Hunters End,
66, Coastal Road
East Preston
BN16 4HY

11th December 2011

Ref: K-28-11 (69, Coastal Road, East Preston)

Indicative Front and Rear Elevations

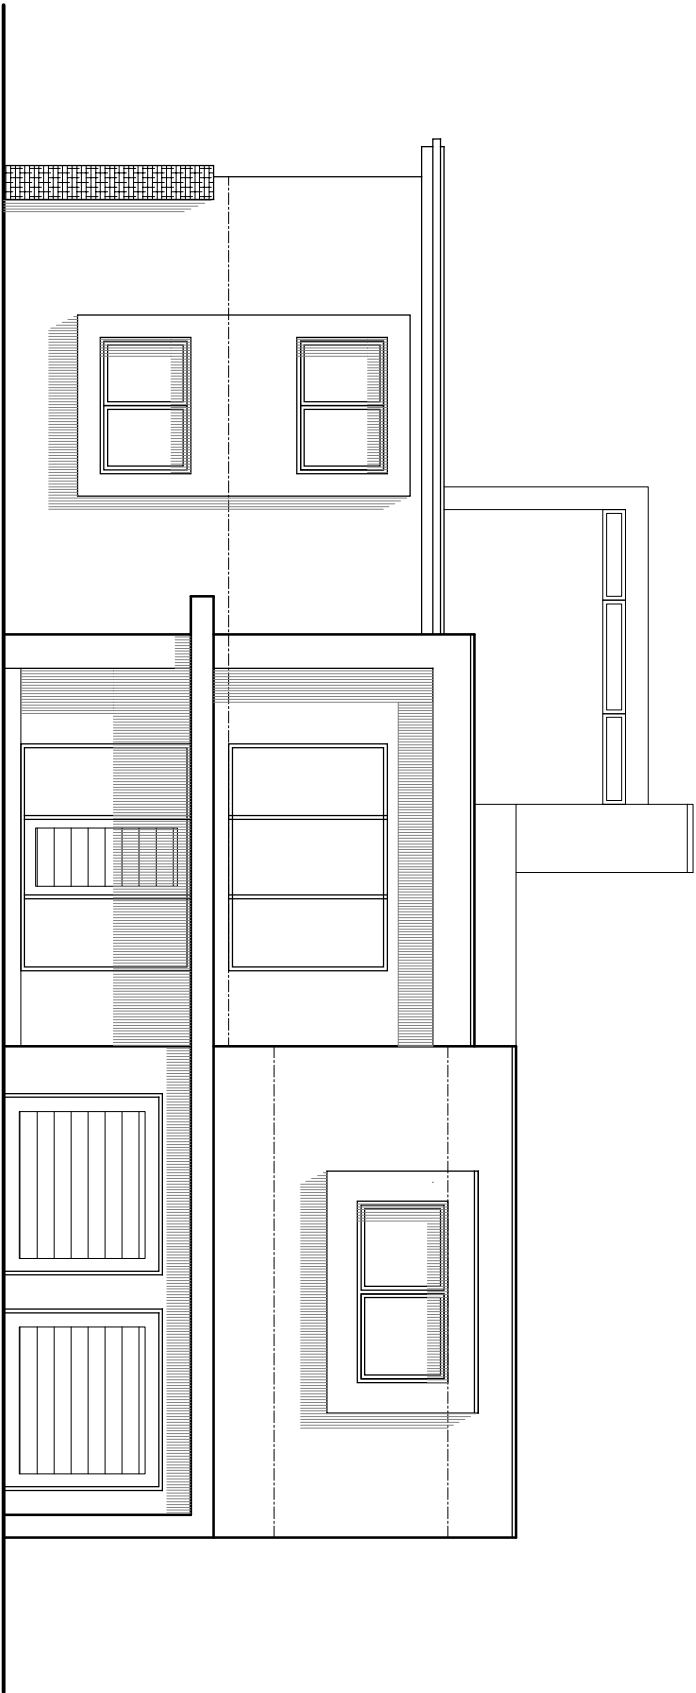
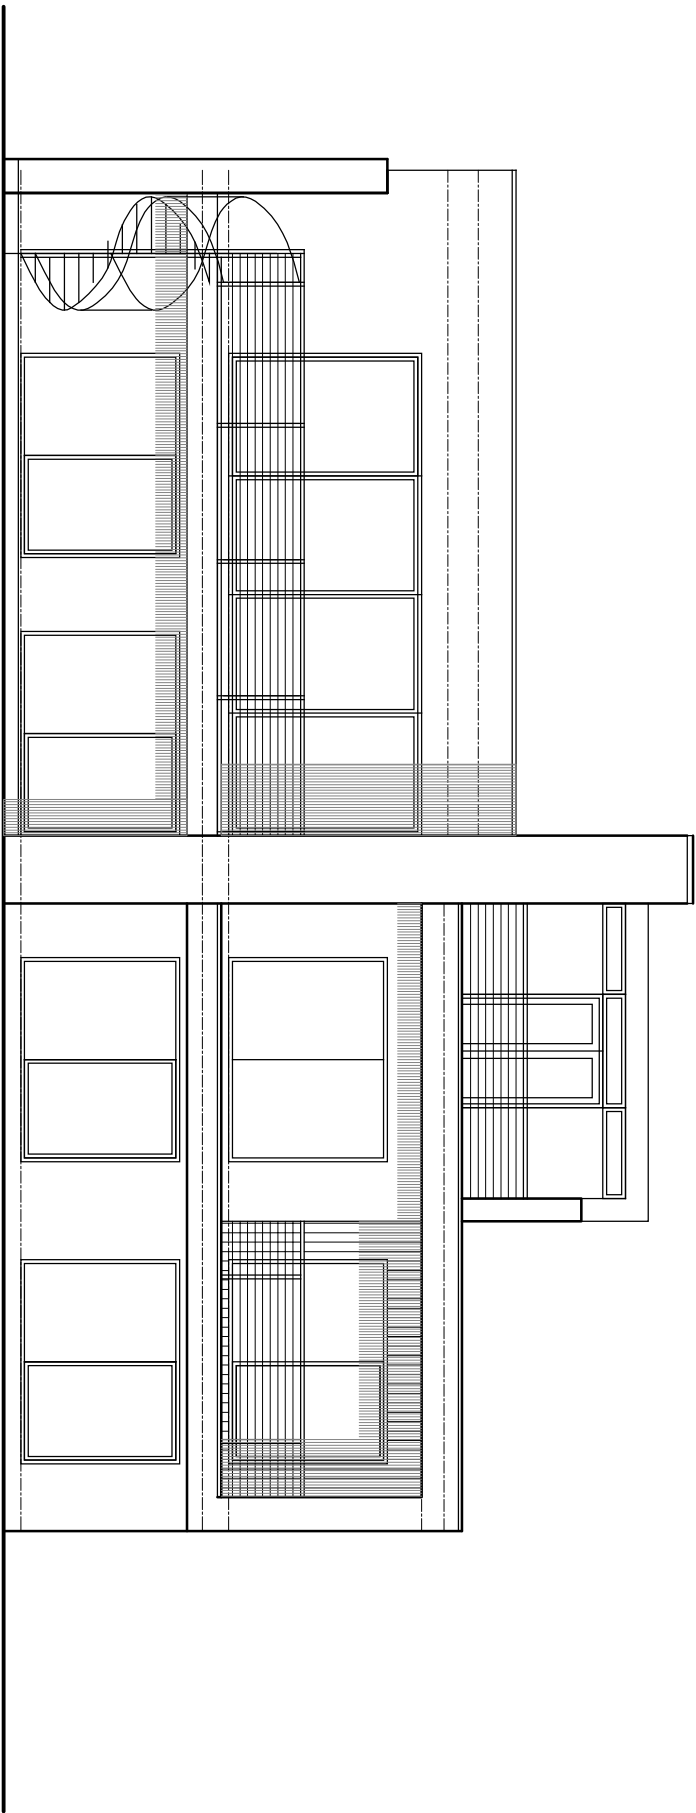
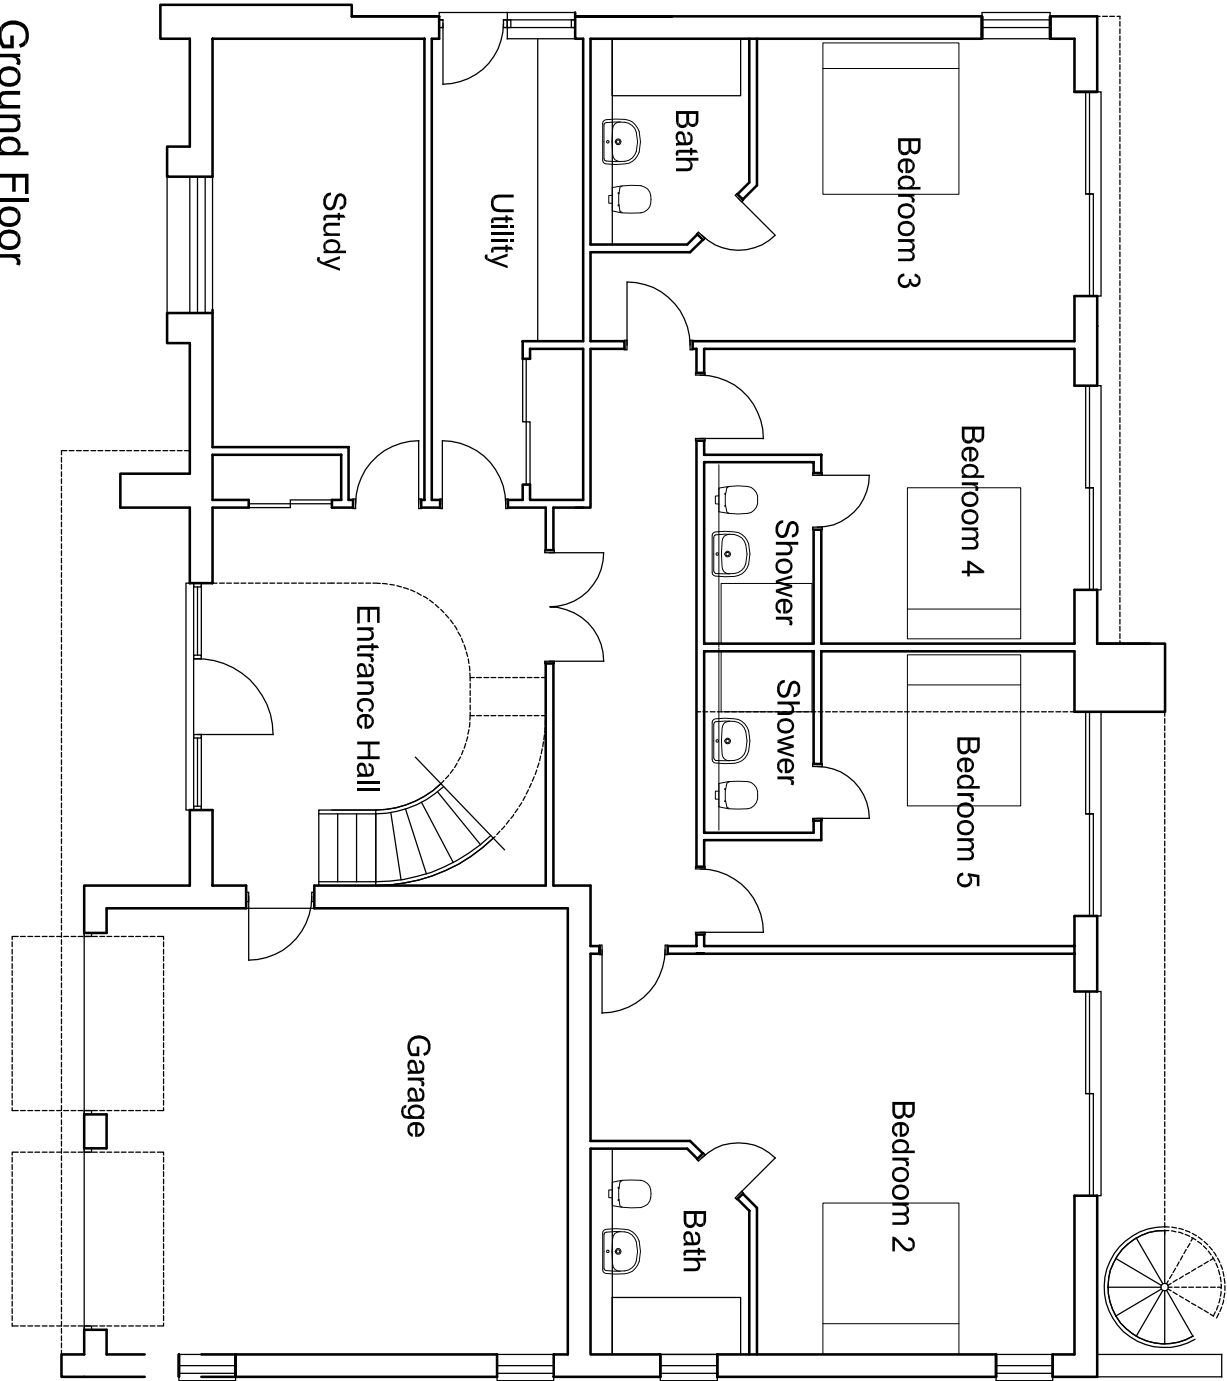
- Intrusive and very ugly nature of the buildings (a completely different style & shape to the existing architecture), in terms of unusual shape, added height, position (blocking sea views, diminishing the feeling of light and with an increased number of high level windows overlooking my property, resulting in decreased privacy.

- Tall, intrusive, unsightly buildings, in a completely different architectural style to the current attractive home - blocking valued sea views, diminishing light and with an increased number of higher level windows, overlooking the surrounding properties, resulting in decreased privacy for current residents.
